Modification 1 – Basement and Construction Hours – Five Ways, Crows Nest (SSD-66826207-Mod-1)

This letter forms Deicorp's written response to the Department's letter dated 3 June 2025 requesting additional information for the assessment of the above modification application.

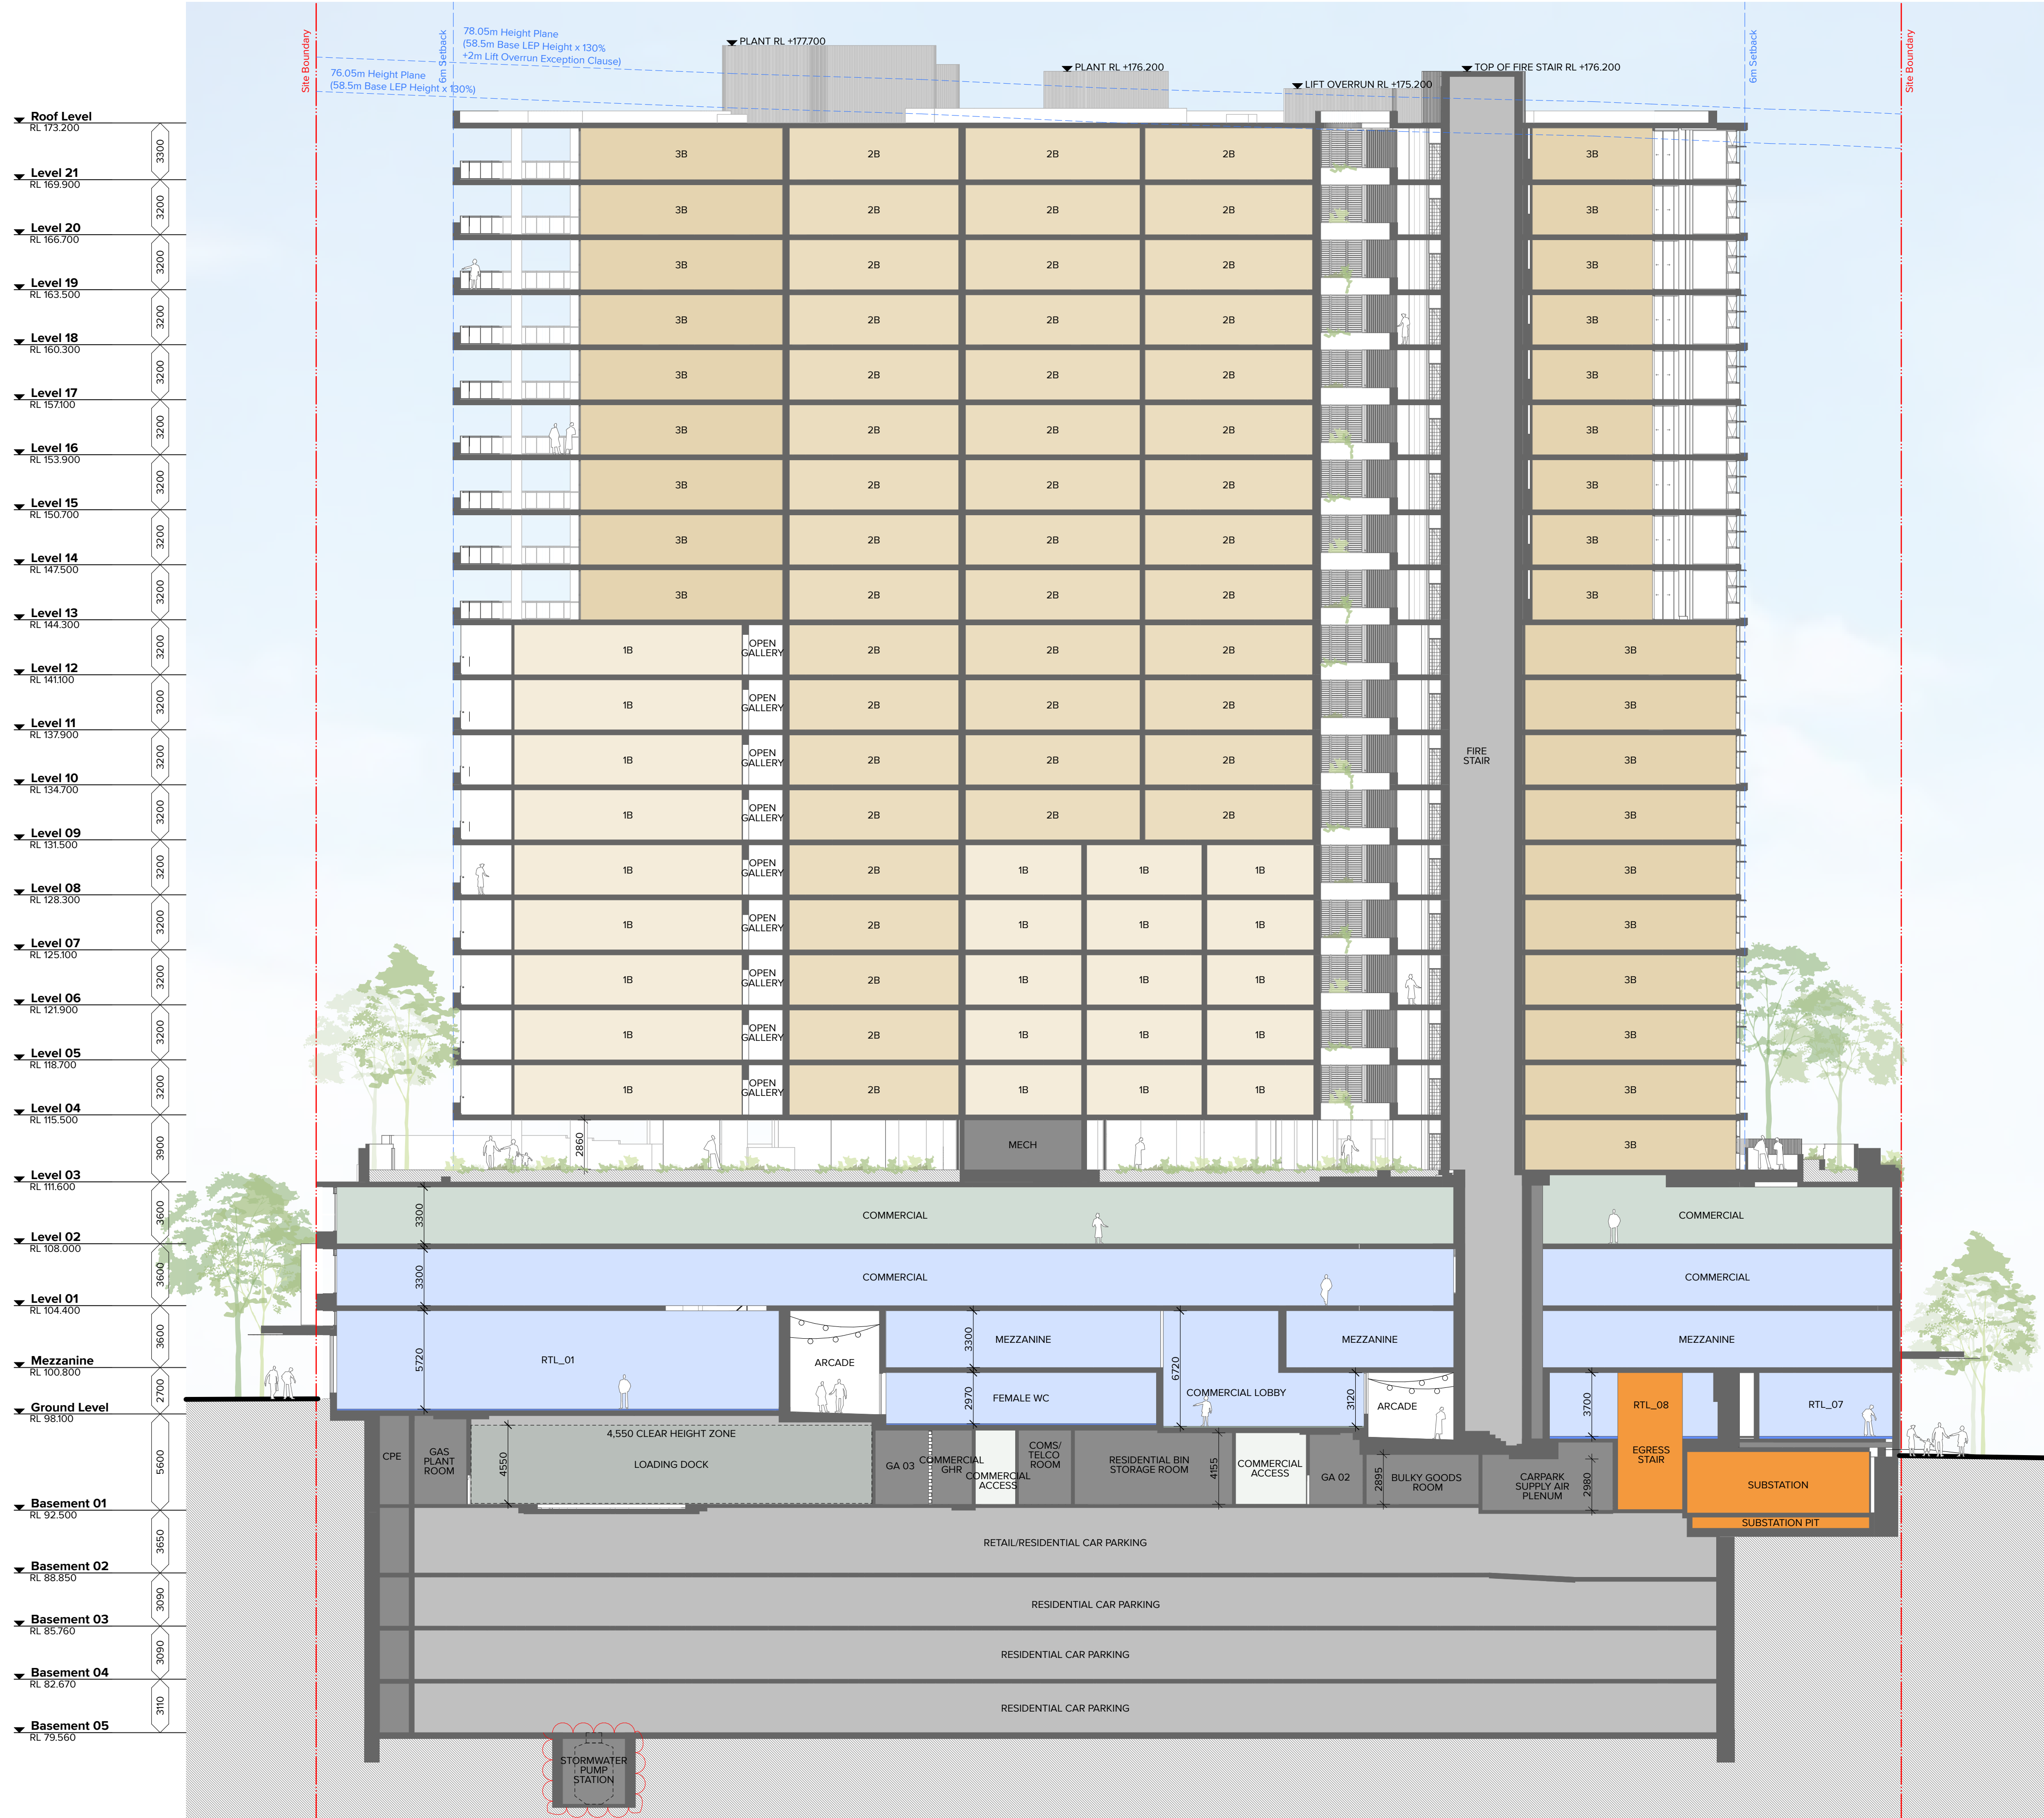
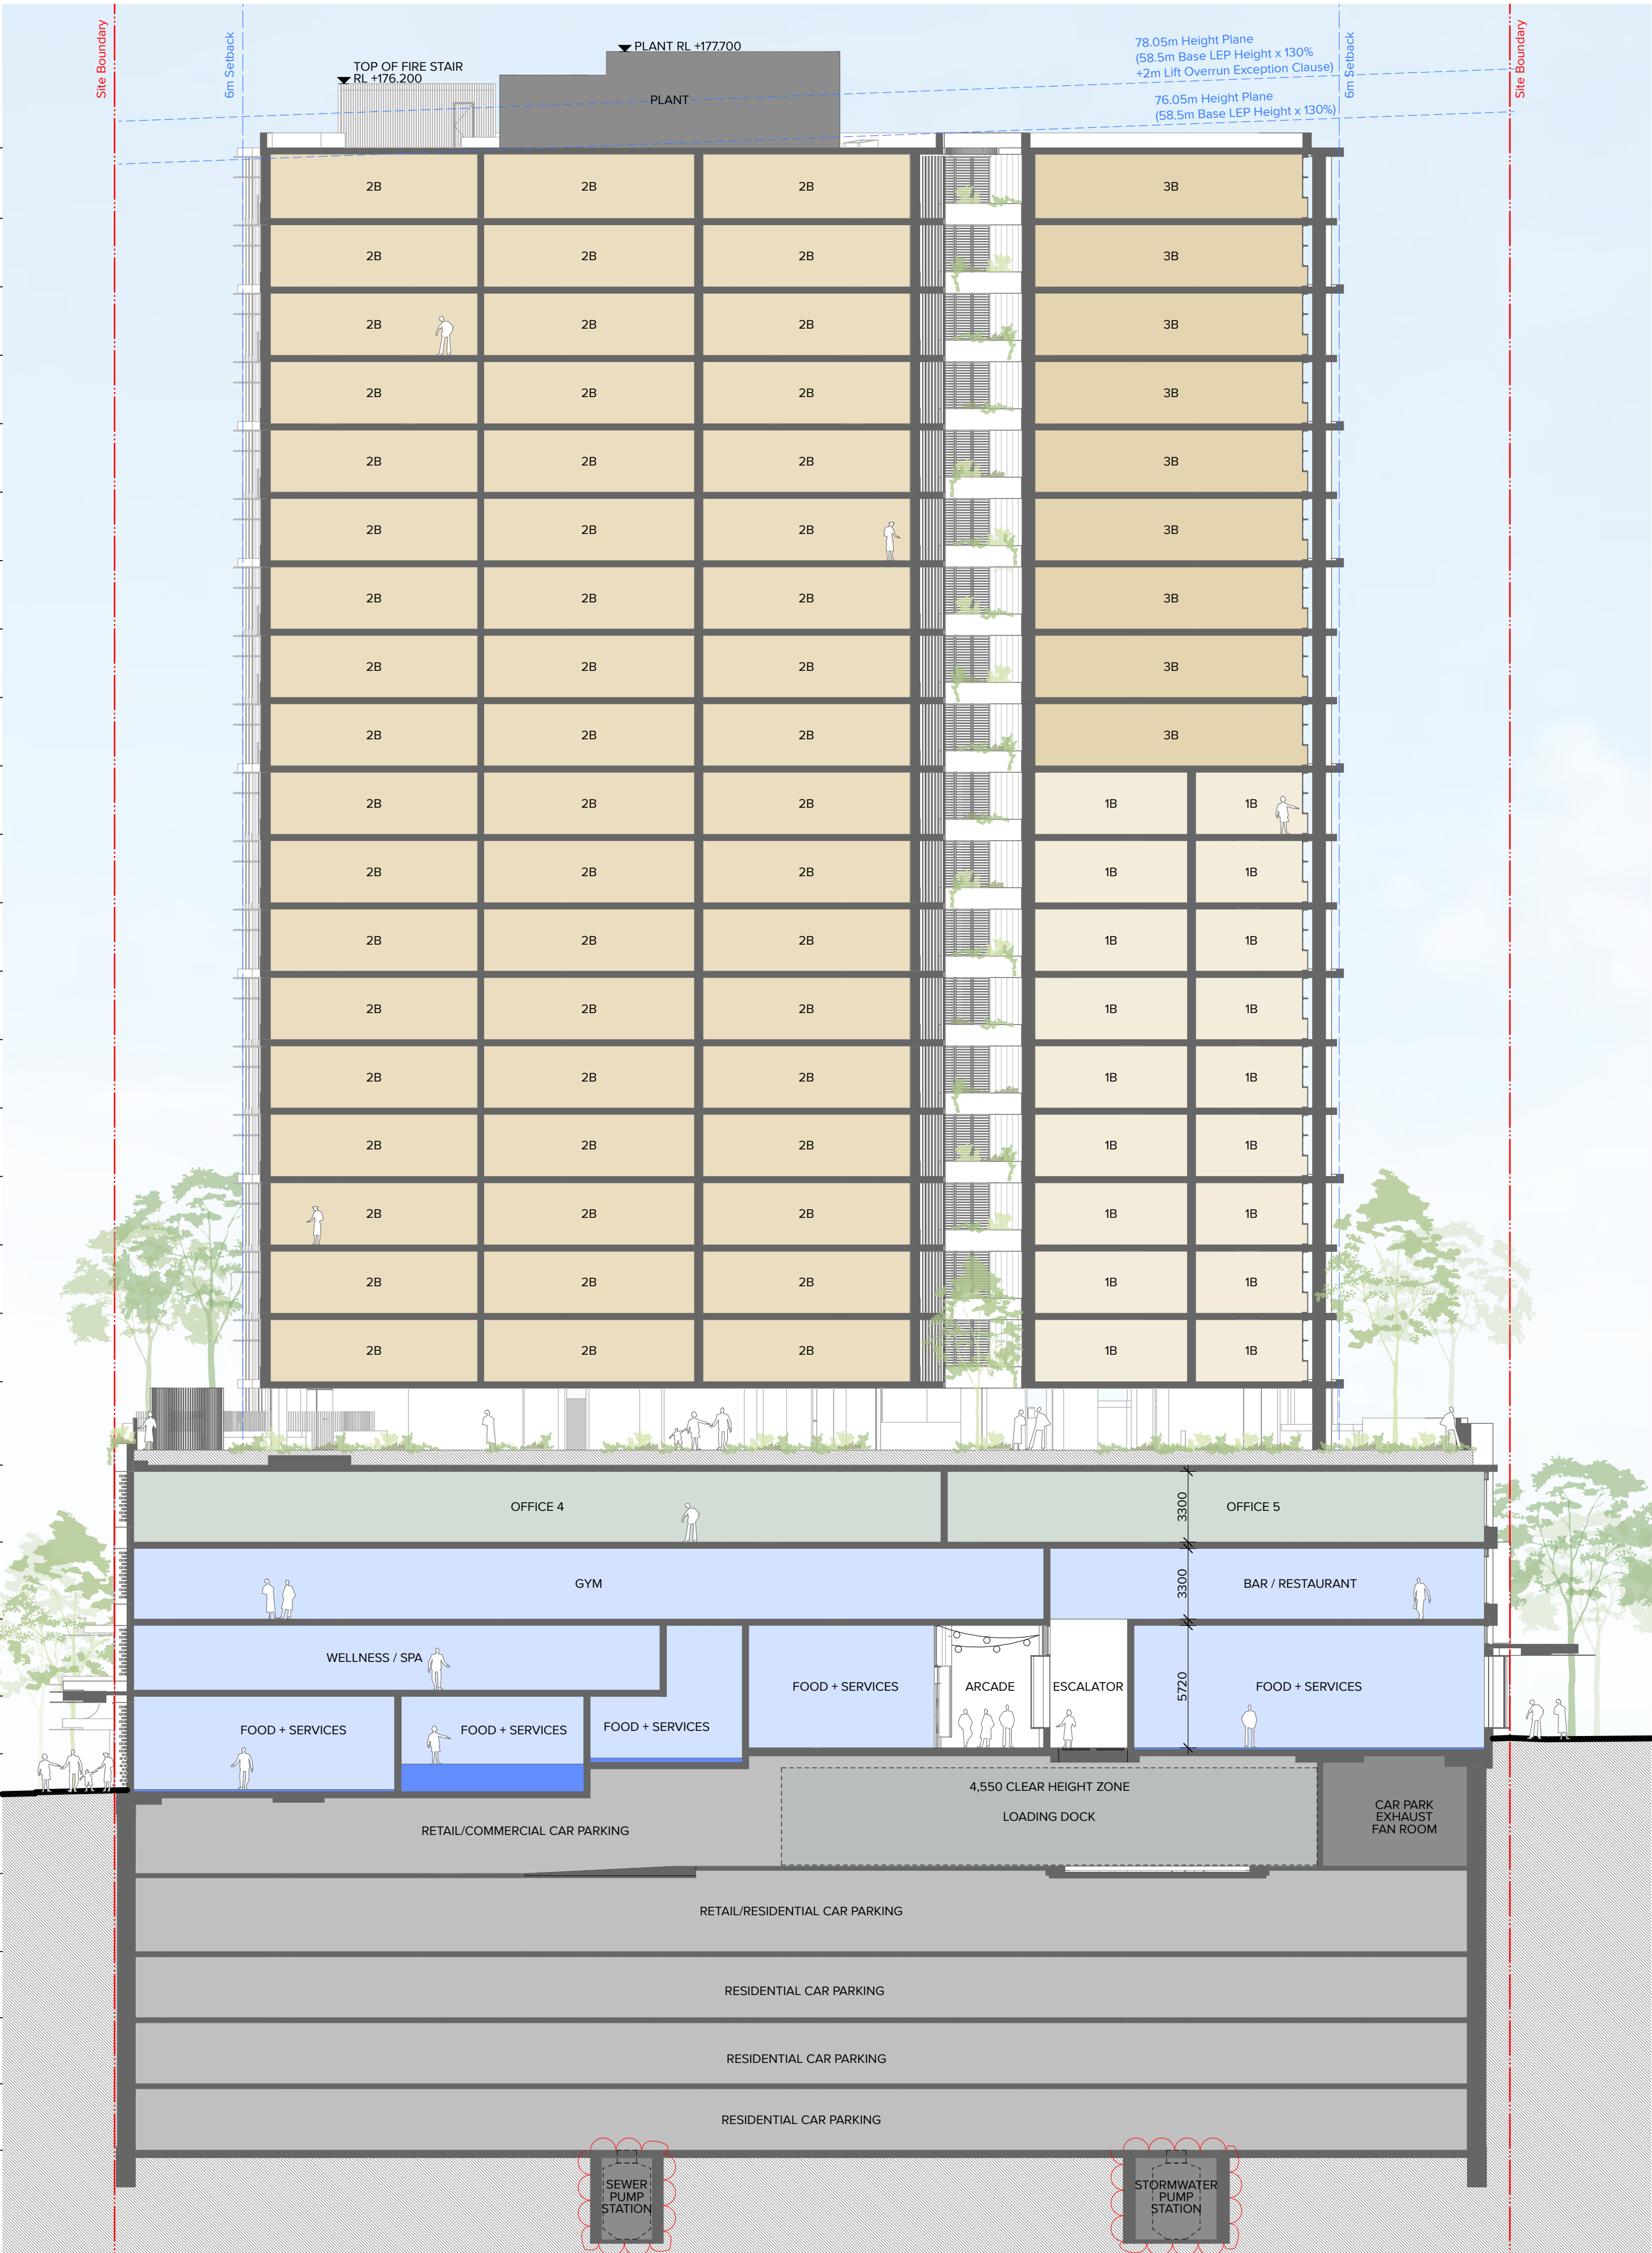
Department Comment	Deicorp Response
Stormwater pump stations	
3. Amend the architectural plans to depict the extent of the two stormwater pump stations located under Basement 5.	The section plans have been updated to include the stormwater and sewer pump stations and are shown at Appendix 3 .
Stratum plans
